DEVELOPMENT HEARING OFFICER

[PR-2020-004171](#)

SD-2024-00098 – PRELIMINARY PLAT
SD-2024-00061 - VACATION OF PUBLIC EASEMENT
SD-2024-00063 - VACATION OF PRIVATE EASEMENT
SD-2024-00066 - VACATION OF PUBLIC EASEMENT
SD-2024-00067 VACATION OF PUBLIC EASEMENT
SKETCH PLAT 12-13-23 (DFT)

PROJECT NAME: FIERRO & COMPANY agent for WILLIAM E. GALBRETH LAND DEVELOPMENT CO. LLC requests the aforementioned action(s) for all or a portion of: TRACT N-7-A-1, BULK LAND PLAT OF TRACT N-7-A-1 TANOAN PROPERTIES zoned R-1D, located at 12300 SAN ANTONIO DR between LOWELL DR NE and TENNYSON ST NE containing approximately 6.653 acre(s). (E-22) [[SD-2024-00061, SD-2024-00063 Deferred from 4/10/24L] 5/8/24L]

PLAT OF TUSCANY VILLAGE, UNIT II LOCATED WITHIN THE ELENA GALLEGOS GRANT PROJECTED SECTION 27, TOWNSHIP 11 NORTH, RANGE 4 EAST, N.M.P.M. CITY OF ALBUQUERQUE BERNALILLO COUNTY, NEW MEXICO FEBRUARY 2024

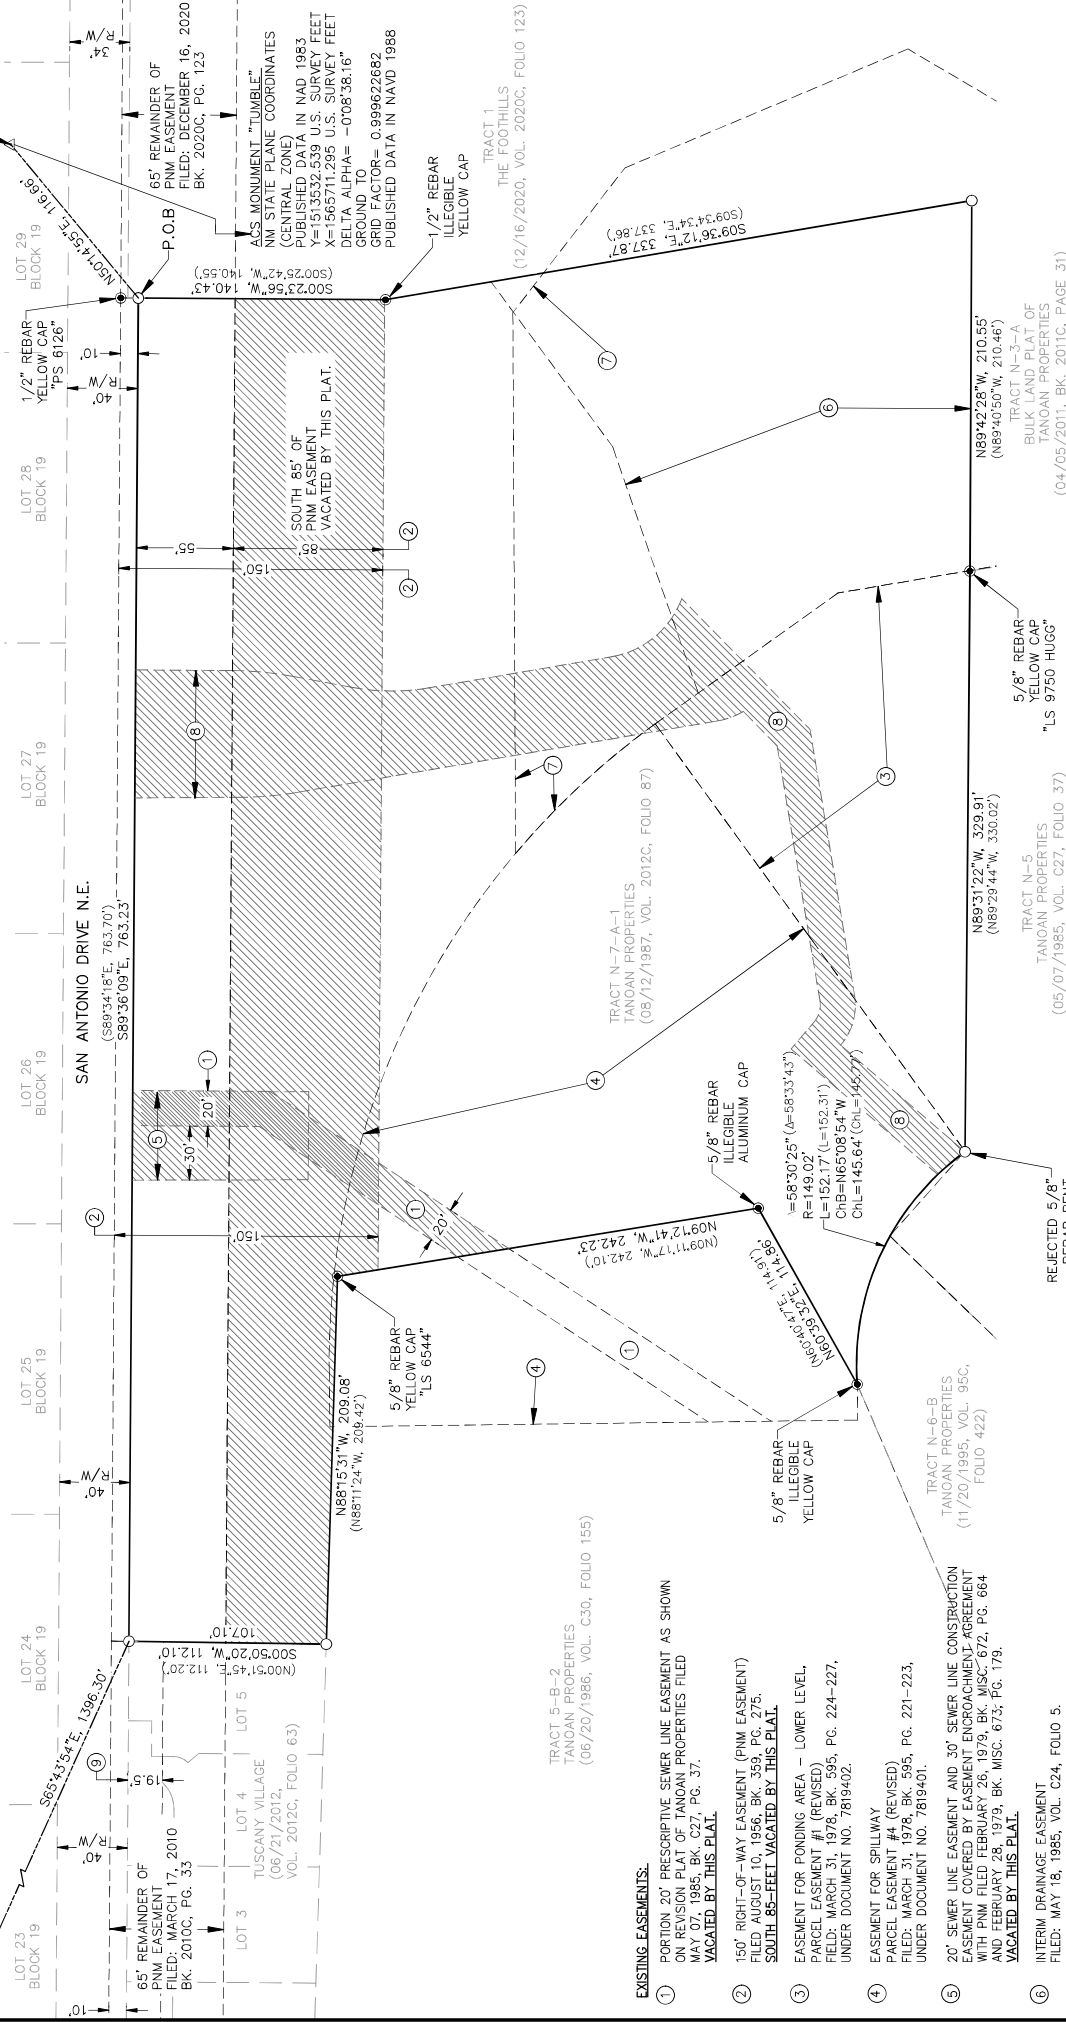
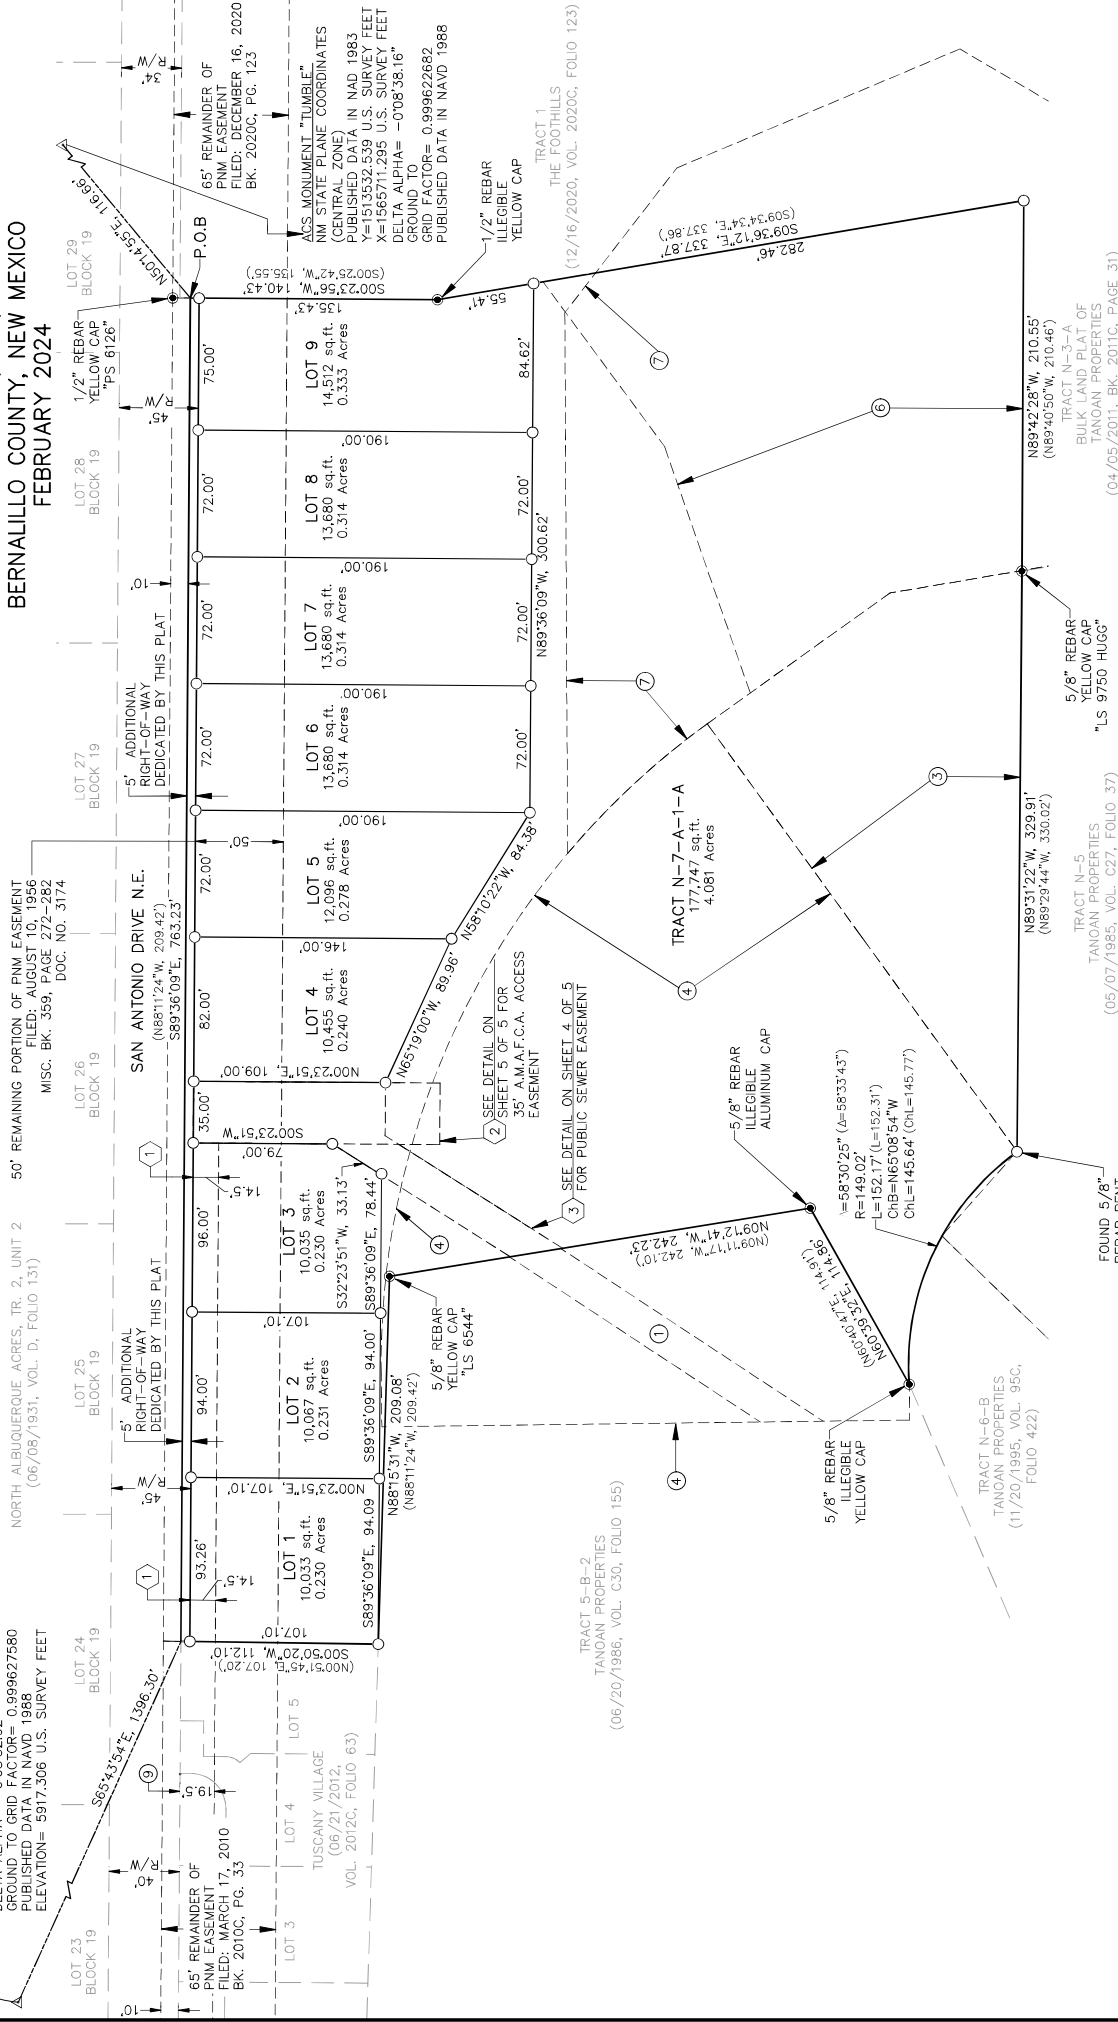
- Planning defers to Code Enforcement for compliance with Dimensional Standards and Contextual Standards (5-1(C)(2)).
- Per 6-6(L)(2)(c) of the IDO, all granted waivers and approved vacations of easement must be noted on the plat by project and application number. Also add the DHO approval date to the plat.
- An Infrastructure List is provided with this application. Planning defers to Water Utility Authority, Transportation, and AMAFCA for review of the content.
